A/110/20/RES

Land South of Water Lane Angmering

Approval of reserved matters following A/99/17/OUT for the Bridge over the Black Ditch providing access to the approved development. This application may affect the setting of listed buildings, may affect the character & appearance of the Angmering Conservation Area & falls within Strategic Site SD9, CIL Zone 1 (Zero Rated).

DRAWING 46353-STN-SBR-AB-DR-CB-0101

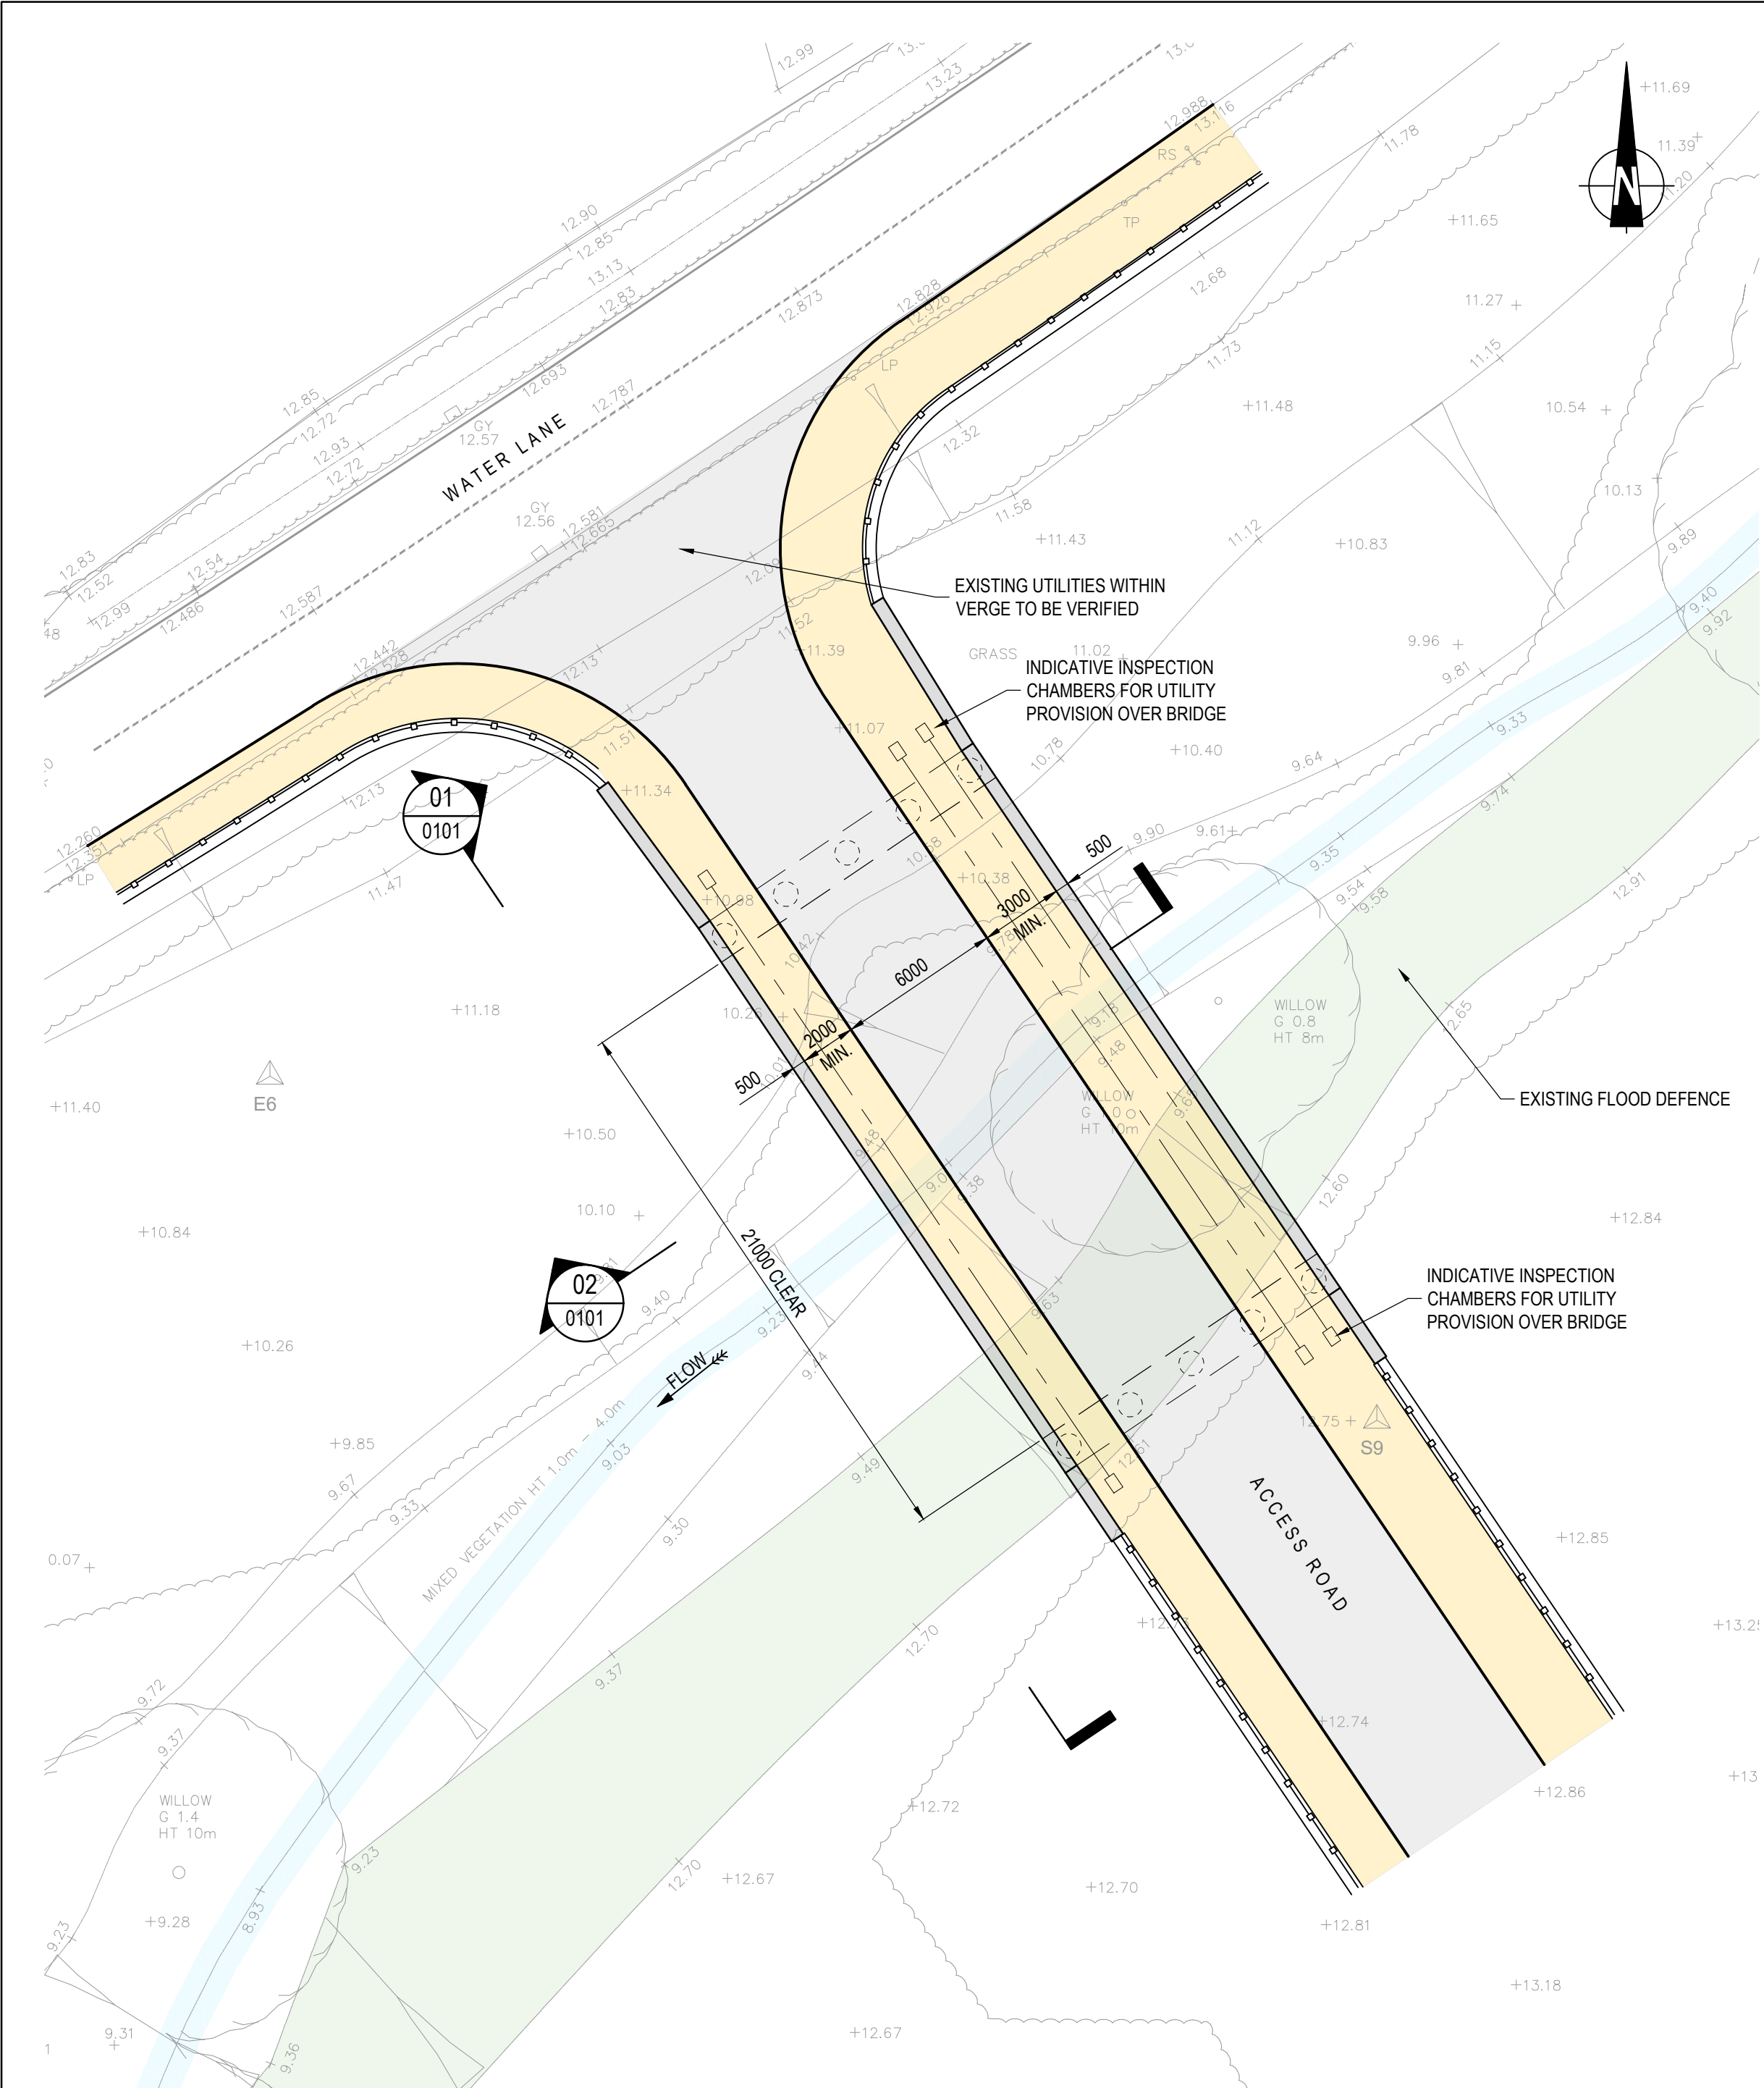
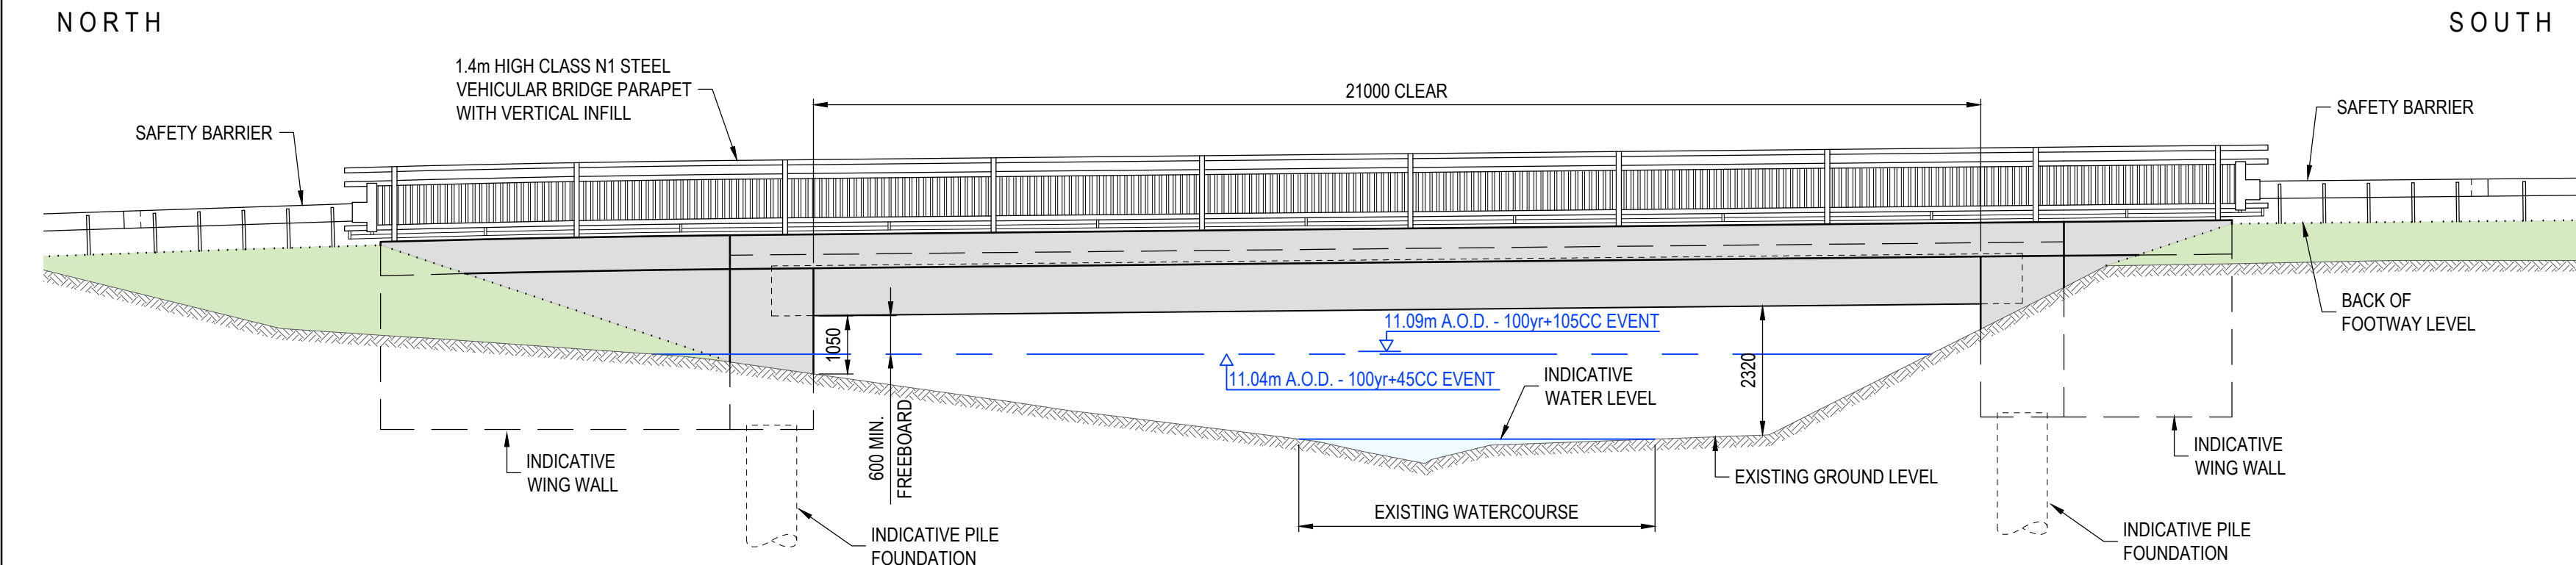
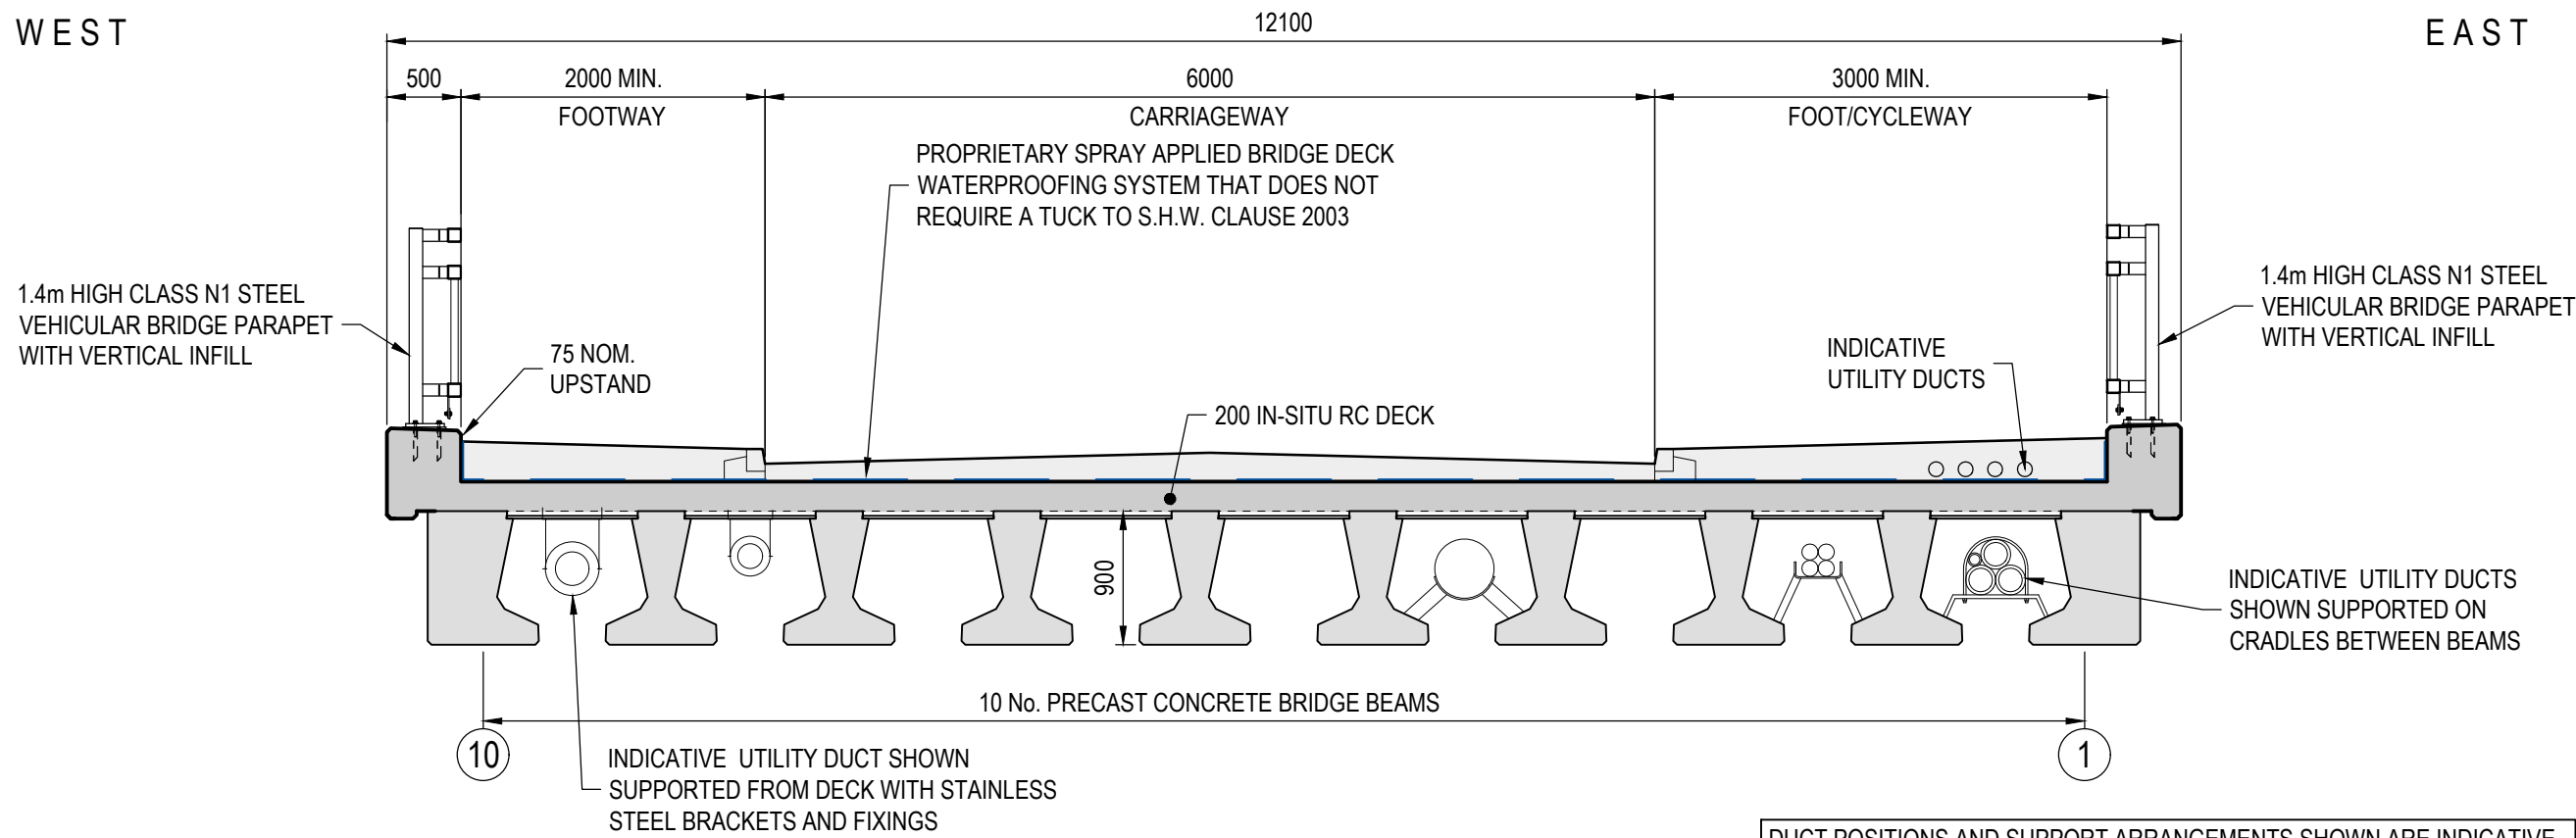
‘We understand from discussions with WSCC LLFA and the Environment Agency that a re-evaluation is being undertaken to establish if this crossing should be a culvert rather than a bridge in order to restrict flow and provide flood alleviation to the village downstream. We therefore do not recommend this application is approved at this time as proposals may fundamentally change.’

The second paragraph above is particularly pertinent. Firstly, it refers to the flooding problem downstream due to the inadequate conveyance capacity of the Black Ditch highway culvert. Secondly, it seems to me that if, instead of the clear span bridge proposed as part of Application A/110/20/RES, a highway embankment/dam carrying a road at the same level as the bridge deck is substituted, and the drainage calculations in A/109/20/RES are reworked to rely on attenuation online on the Black Ditch upstream of the highway embankment/dam, a more effective solution will be achieved delivering wider benefits and reducing flood risk overall.

The throttling control measure for Black Ditch flow through the dam would operate to ensure that critical water levels downstream are maintained below levels that would result in flooding. Such a system of operation is relatively easy to achieve.
